13 February 2024

Application for a Development Consent Order by Gatwick Airport Limited for the Gatwick Airport Northern Runway Project (Ref. TR020005) (the "Application") – Request for proposed changes to the application for development consent

Further to this notification, please find enclosed the Applicant's formal request to the ExA to change the Application (the "Change Application"). This Change Application relates to three proposed changes to the Application namely:

DRAWING TITLE
**Proposed Airport Works
(Version 3 Tracked Changed with
Project Change 1)**

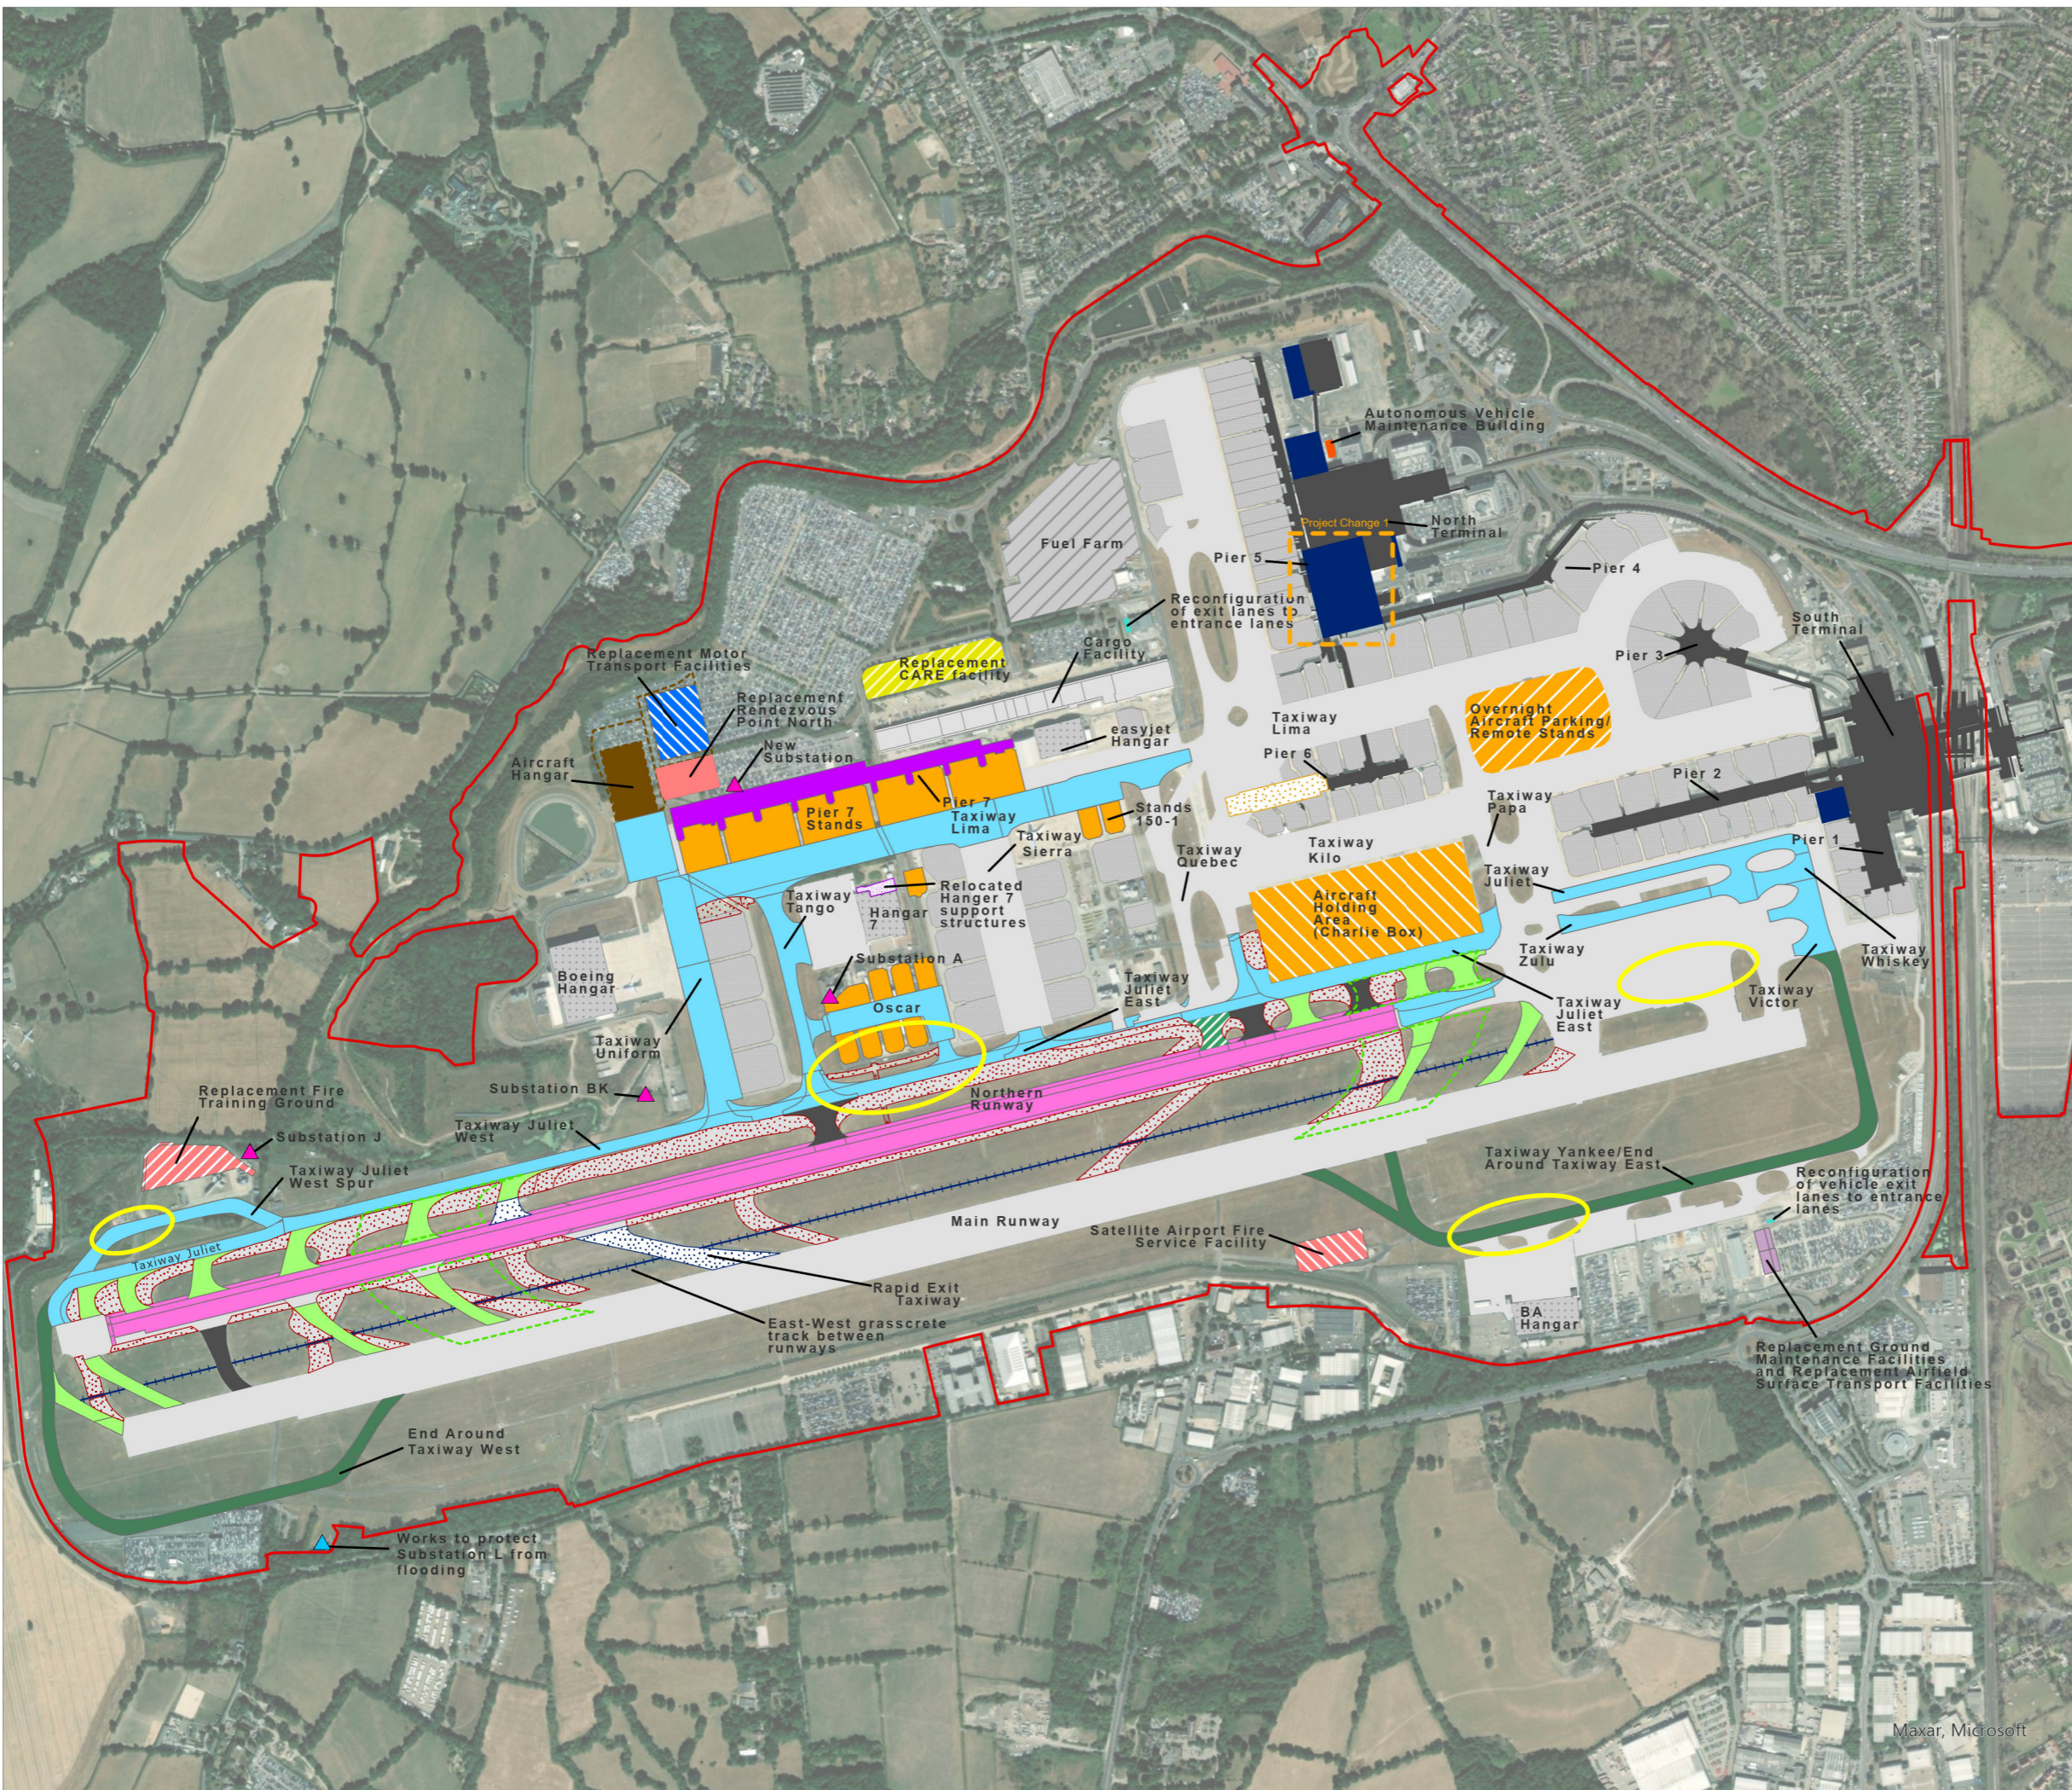
- Project Change 1: Extension to the design parameters for the North Terminal International Departure Lounge (NT IDL) proposed southern extension.
- Project Change 2: Reduction in height of the proposed replacement Central Area Recycling Enclosure (CARE) facility and change in its purpose.
- Project Change 3: Revision to the proposed water treatment works.
